DEVIATION REQUEST AND DECISION FORM

Project Name :	Grandwood
Schedule No.(s) :	6119000003
Legal Description :	S2N2, EX PT TO HIGBY RD CONV BY REC# 205092691 W/MR SEC 19-11-66

Deviation No. 3 (09-21-2019): The request is for intersection approach grades and "mid-block" centerline roadway grades exceeding the maximum allowable in the ECM. The details are described below. See attached Deviation Exhibits 3, 3a and 3b.

Deviation Exhibit 3
**Centerline
Roadway Grades**
Grandwood Ranch (LSC# 185020)

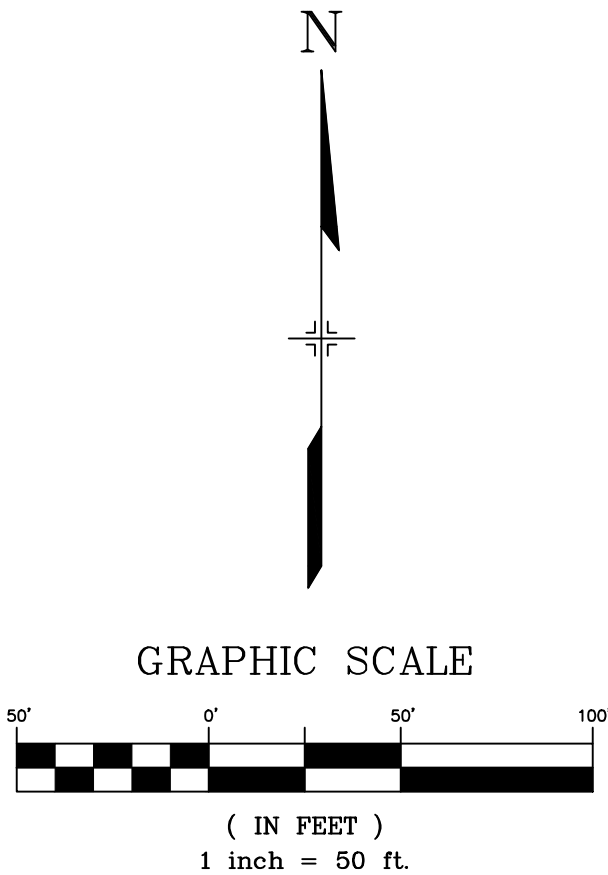
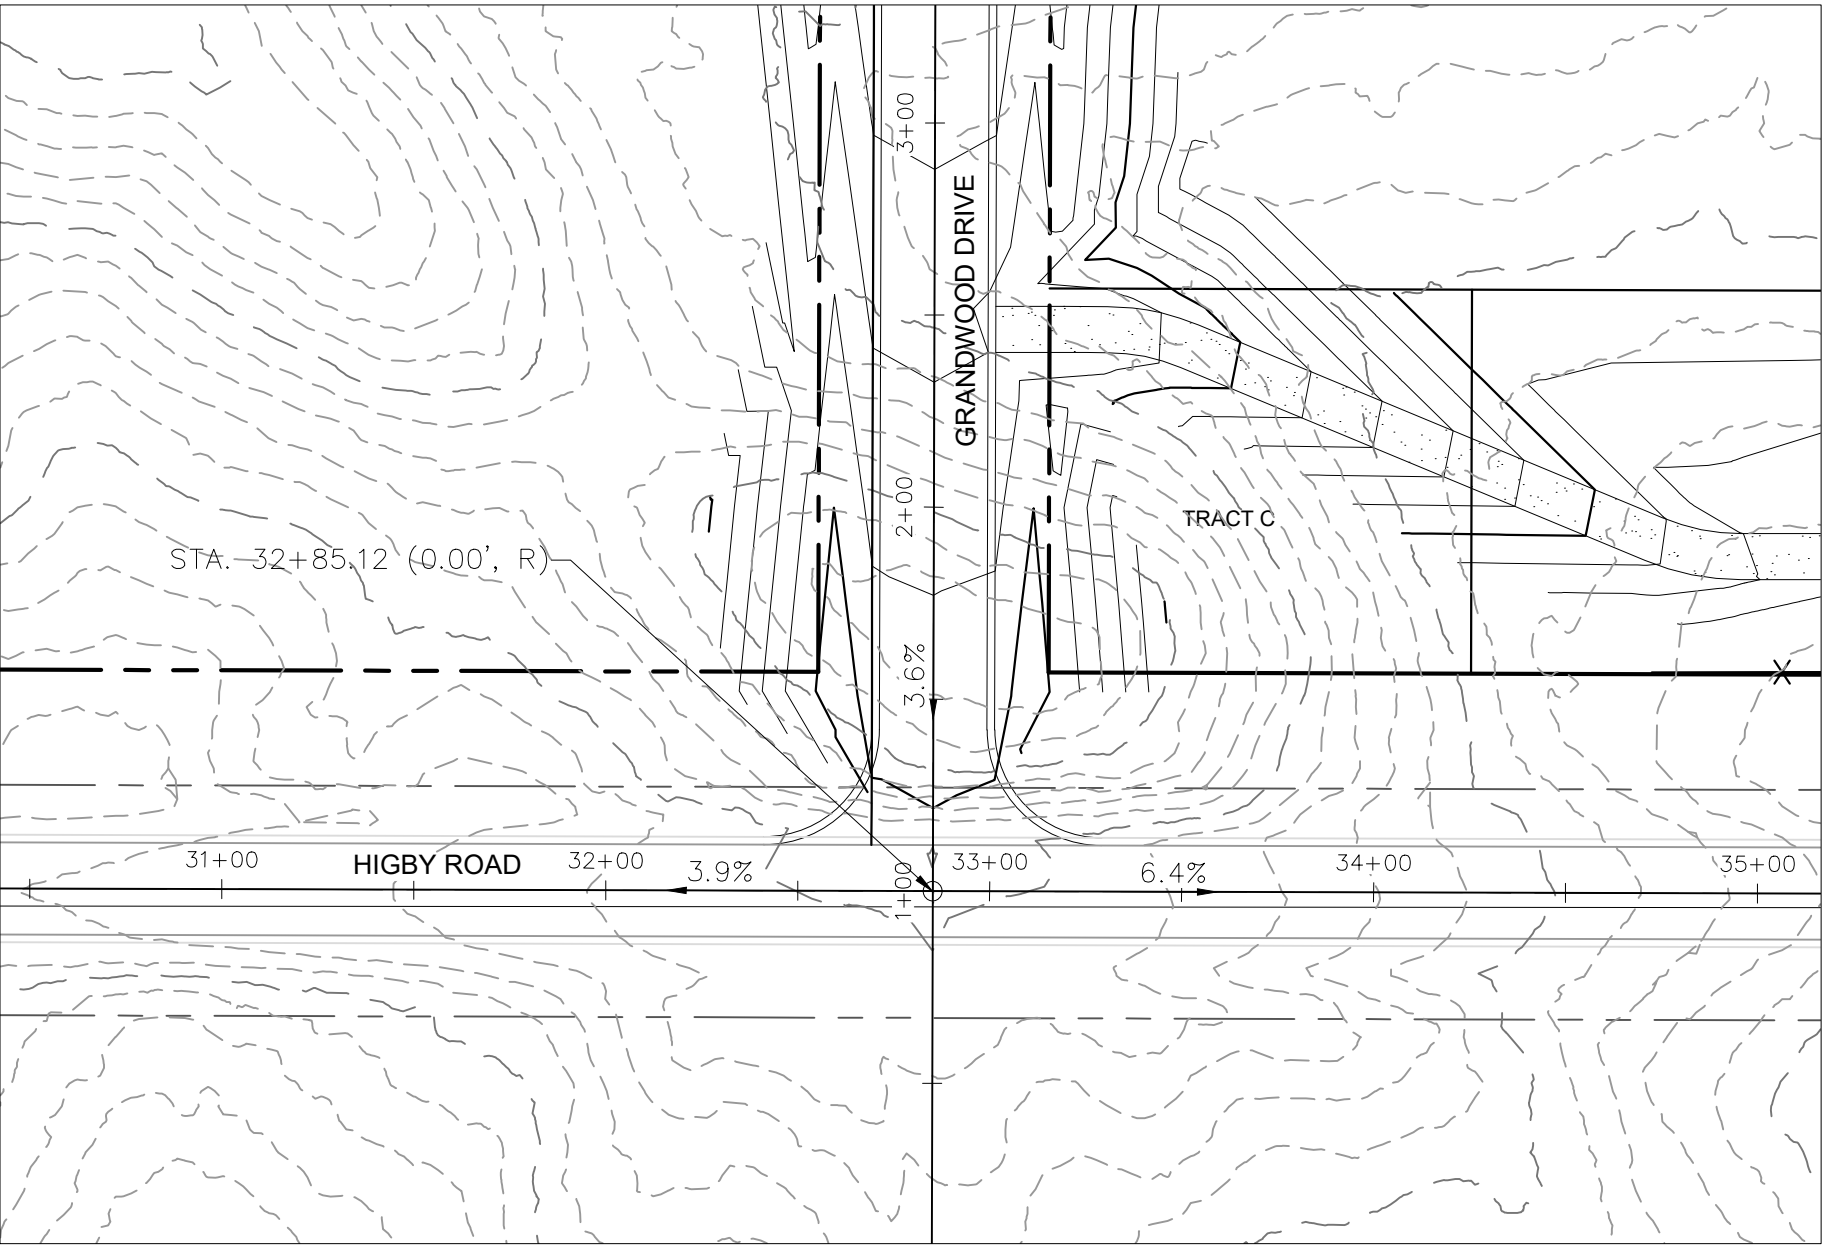
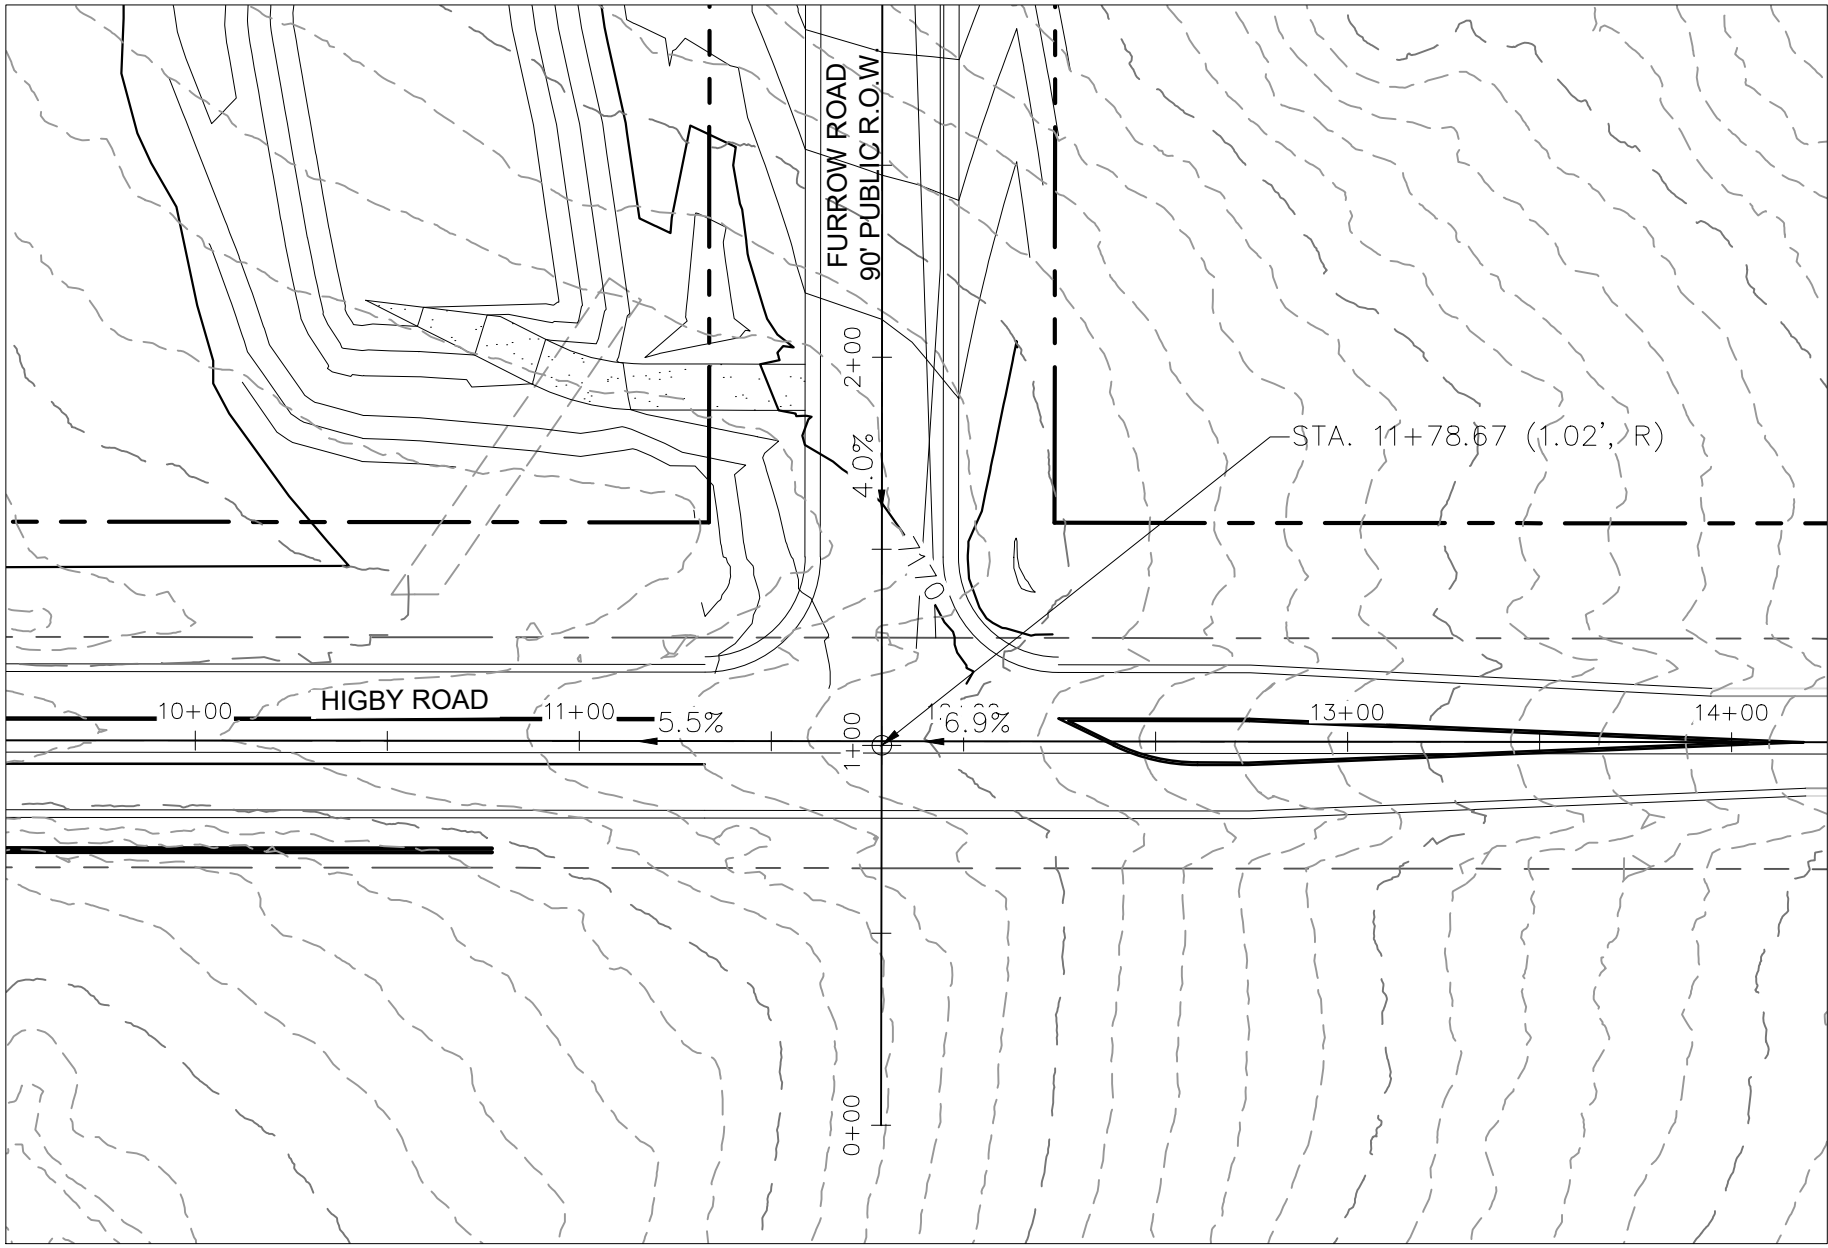
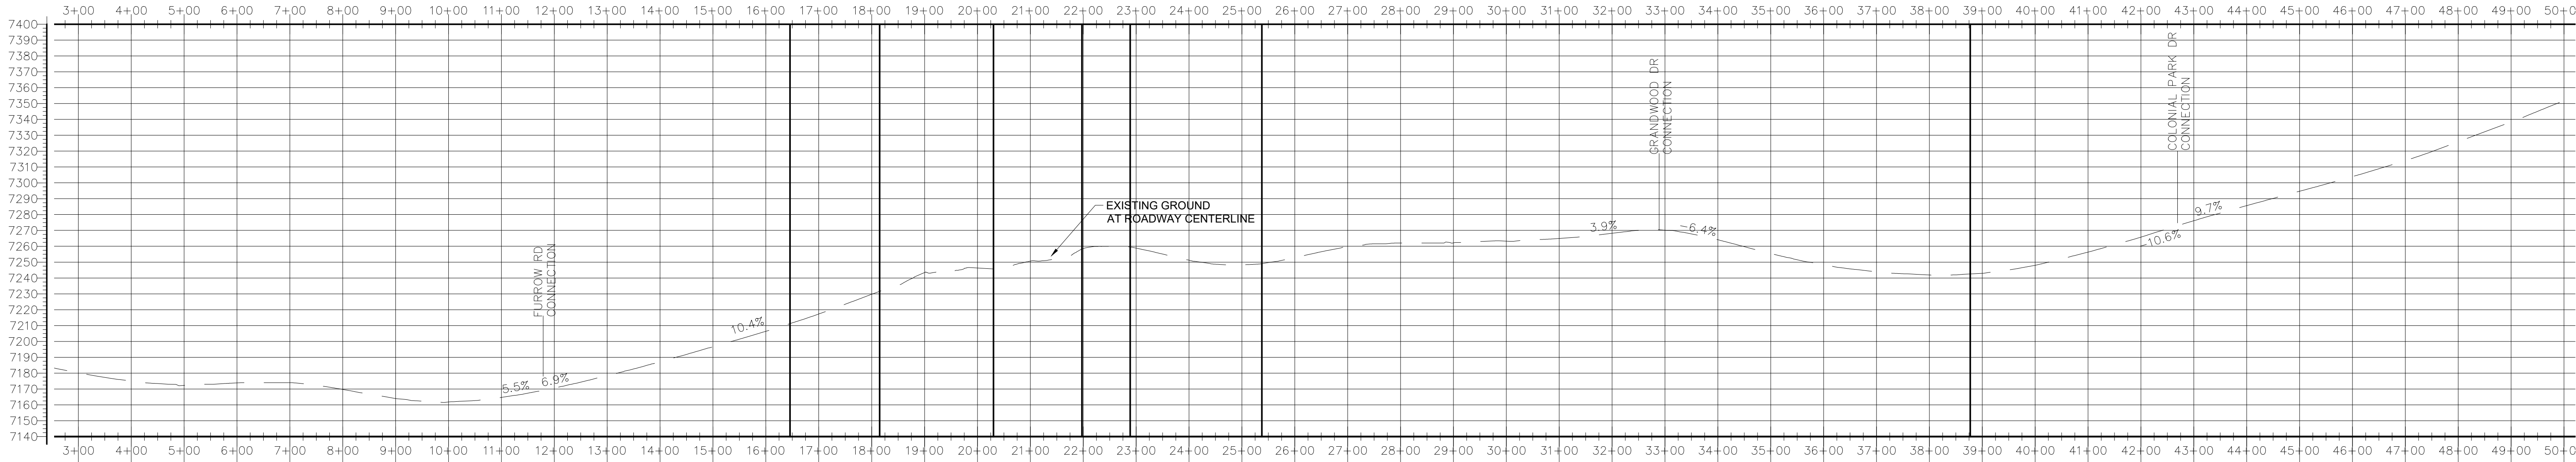
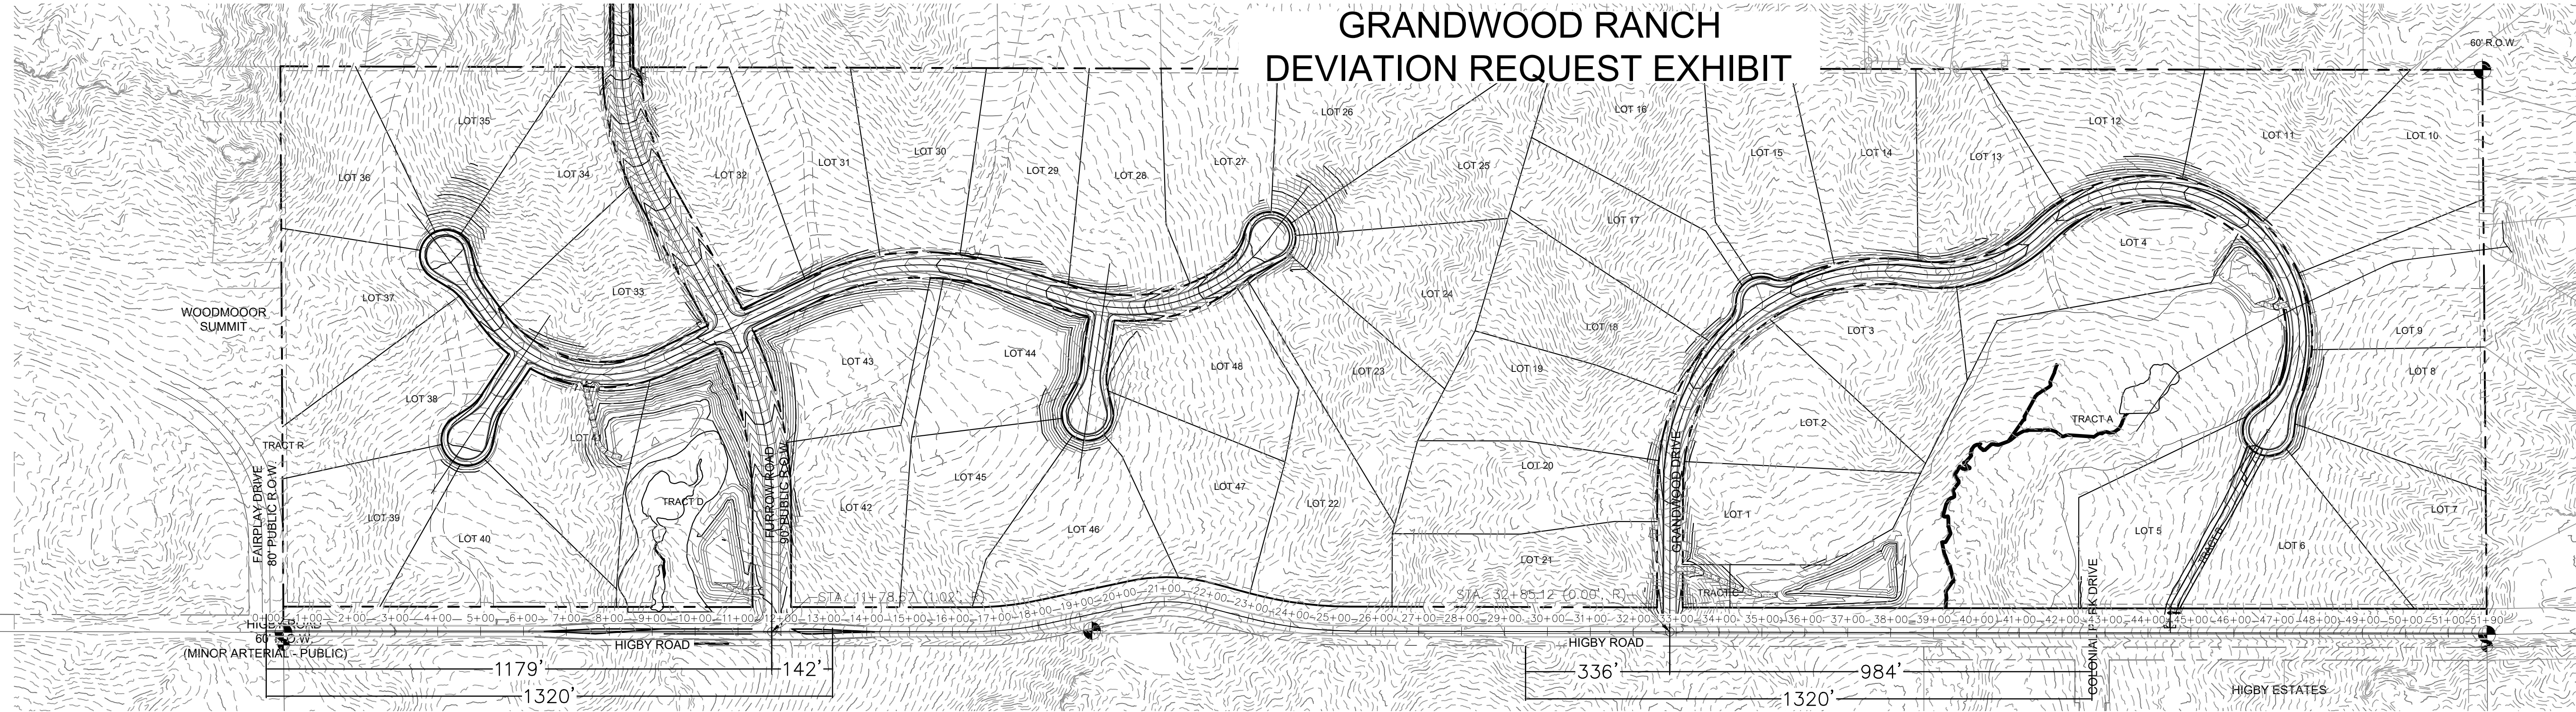
Will be reviewed in greater detail once the missing exhibits are provided.

exhibits are missing.
